CITY OF ALBUQUE

July 17, 2020

Re: Cottonwood Mall Retail Pad - 10000 Coors Blvd NW
Erosion Sediment Control Plan
Engineer's Stamp Date 3/23/2020 (B14E004G)

TEMPORARY EROSION AND SEDIMENT CONTROL PLAN

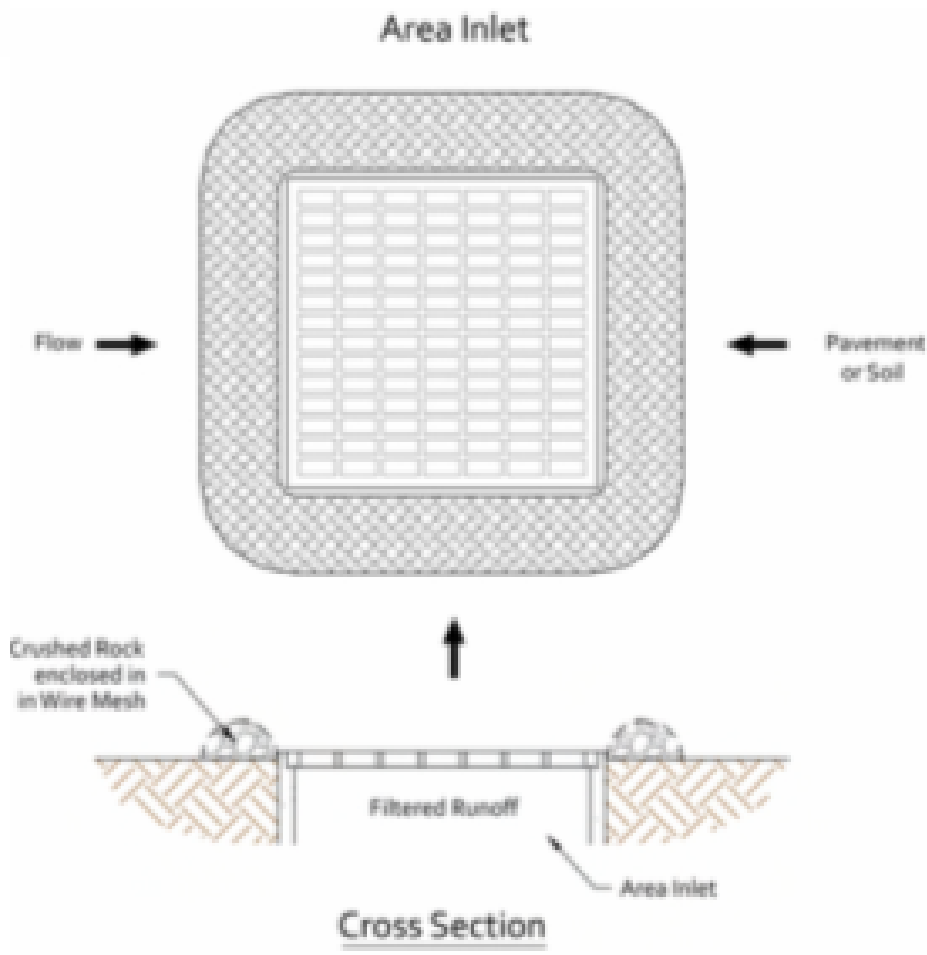
Based upon the information provided in your submittal received 7/15/2020, the above referenced plan is conditionally approved to be included in the SWPPP and to apply for an ESC Permit/eNOI for Grading and Building Permit with the condition that the silt fence must be embedded 6" minimum per NMAC 20.11.20 and the Albuquerque Construction Site Manual.
